KIRKLEES METROPOLITAN COUNCIL INVESTMENT & REGENERATION SERVICE

DELEGATED DECISION TO DETERMINE APPLICATIONS FOR CONSENT, AGREEMENT OR APPROVAL REQUIRED BY CONDITION

Reference No:	2023/44/93464/W
Site Address:	Land at, Lingards Road, Slaithwaite, Huddersfield, HD7 5HY
Description:	Discharge of conditions 4 (Phase II report), 5 (Remediation Strategy), 8 (Construction Environmental Management Plan), 9 (CEMP: Biodiversity), 10 (road condition survey), 11 (estate roads), 12 (Lingards Road footway), 13 (highway retaining walls), 14 (highway embankments), 15 (Stability Remediation Strategy), 16 (drainage infrastructure in highway), 17 (drainage scheme), 18 (flood routing), 19 (temporary drainage), 20 (Arboricultural Method Statement), 21 (bridge details), 22 (green retaining wall), 23 (Ecological Design Strategy), 24 (ecological measures), 25 (materials), 26 (footpath connections), 27 (landscaping), 28 (lighting), 29 (temporary waste arrangements), 30 (pedestrian improvements), 31 (pedestrian improvements) and 33 (cycle parking) of previous permission 2020/93954 for erection of 42 dwellings and associated works

DECISION – Discharge of Conditions – Split Decision

SB HOMES
 LINCARDS ROAD
 PHASE 2 PLAN
 DRG SK 08
 JUNE 2024

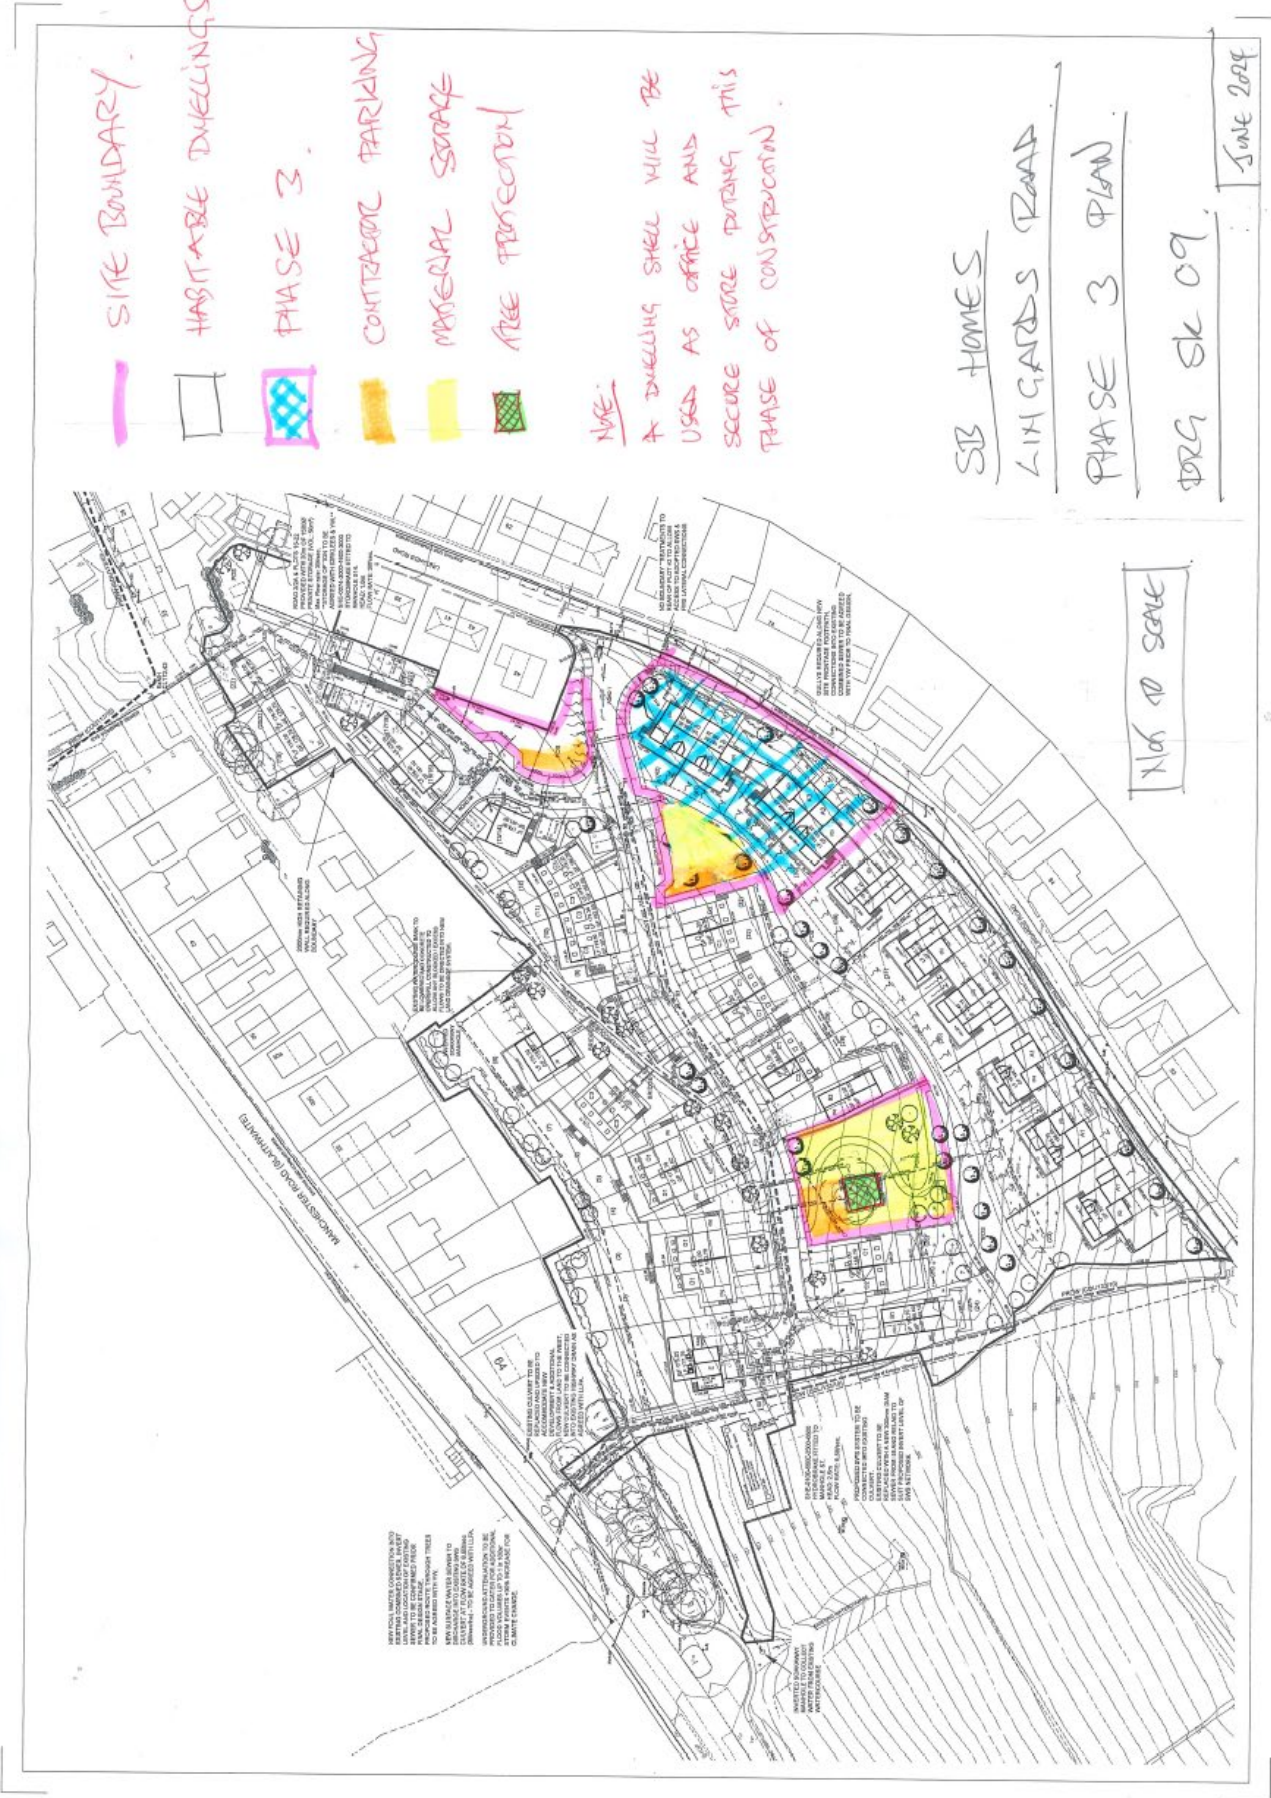
Dedicated parking areas (per phase) are shown in appendix 2 of the report. These are to accommodate a minimum of 20 vehicles, which is considered adequate for a development of this scale.

The above arrangements are considered acceptable to officers and K.C. Highways Development Management.

Appendix 3 – Construction Access and Site Compound

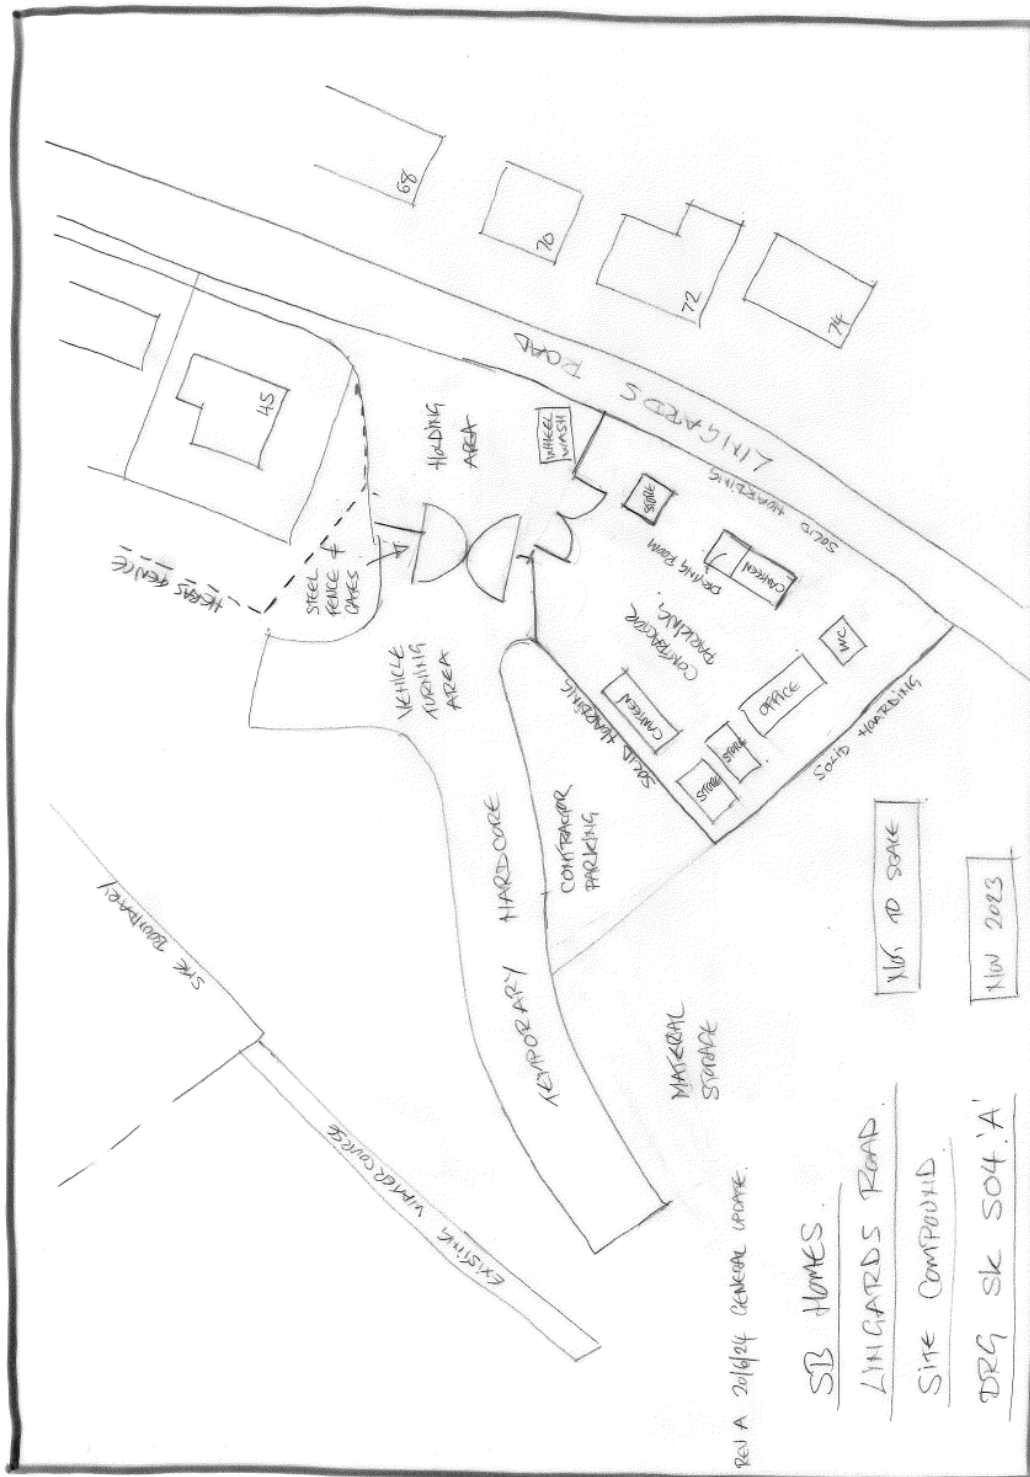
Wheel washing facilities are to be provided across each phase, with the location of the equipment shown in appendix 3. The details provided are acceptable. This equipment would operate alongside the inspection of vehicle wheels prior to leaving, with debris to be removed using the wash. Used water would be collected to avoid pollutants entering the sewer network.

The above arrangements are considered acceptable to officers and K.C. Highways Development Management.
